**Application Number: 2023/62/93495/E**

We, of Dewsbury and District League of Friendship, based at Howlands, School Street, Dewsbury WF13 1LD hereby object to this planning application.

East Elevation As Proposed
 Scale 1:100
 0m 1m 2m 3m 4m 5m

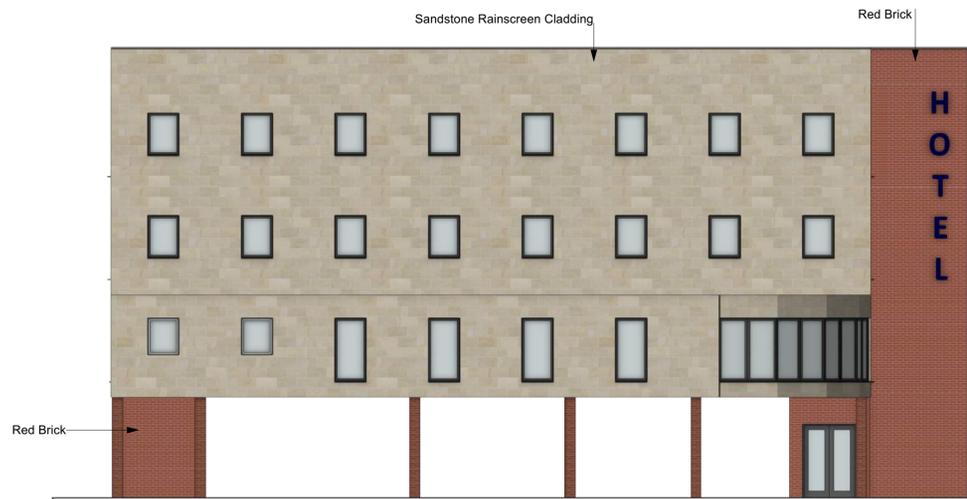
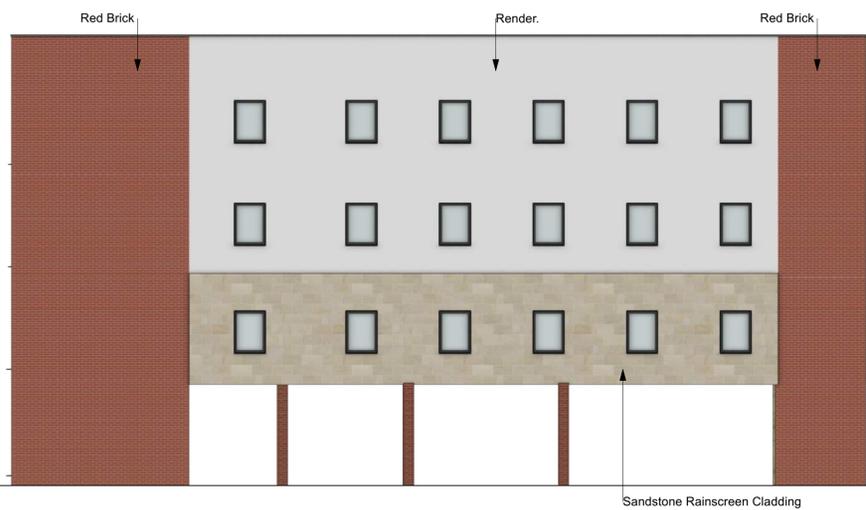
On the basis that Daisy Hill is a Heritage Action Zone we consider this to apply in the context of this proposal, as any development within such close proximity to Daisy Hill will impact on its Heritage. The building proposed is not in keeping with the architectural design and history of the immediate surrounding area and we consider it would not add value or aesthetic improvement were it given the go-ahead.

Ground Floor Site Plan As Proposed  
Scale 1:100  
0m 1m 2m 3m 4m 5m

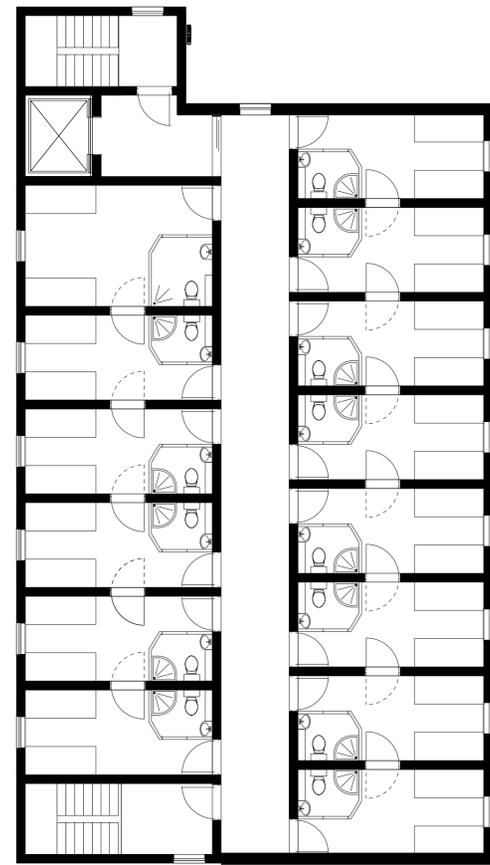
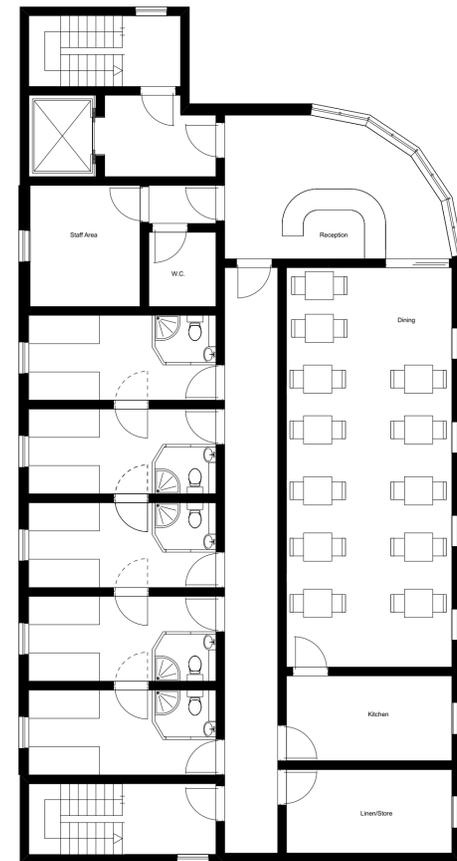
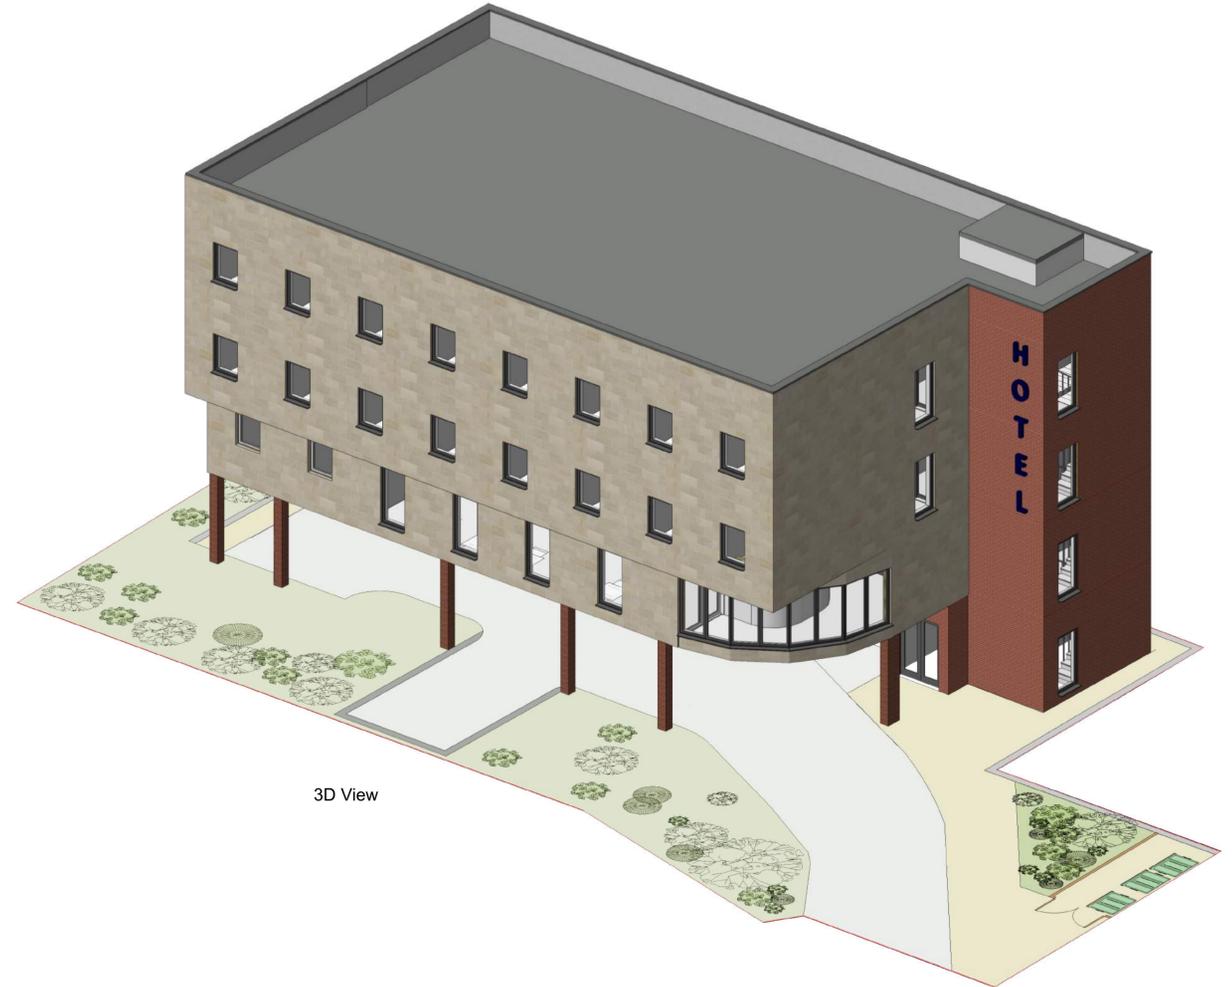
- A Landscape Design is not provided;
- An Archaeological intrusive survey is required prior to approval;
- There are no dimensions on the drawings to assess the size of the rooms nor is there any indication as to how accessible these rooms will be including storage and layout of toileting facilities;

- The rooms do not show luggage storage, wardrobe/drawers;
- It is not clear exactly what the intended purpose of this hotel is. There is an underlying suggestion that it may be for bail/asylum hosting purposes which would have a different impact on the area it is being located in;

- No rising mains or service ducts are shown in the plans;
- No sprinkler tank is shown in the plans, constituting a risk that ought to be considered by the Fire services.
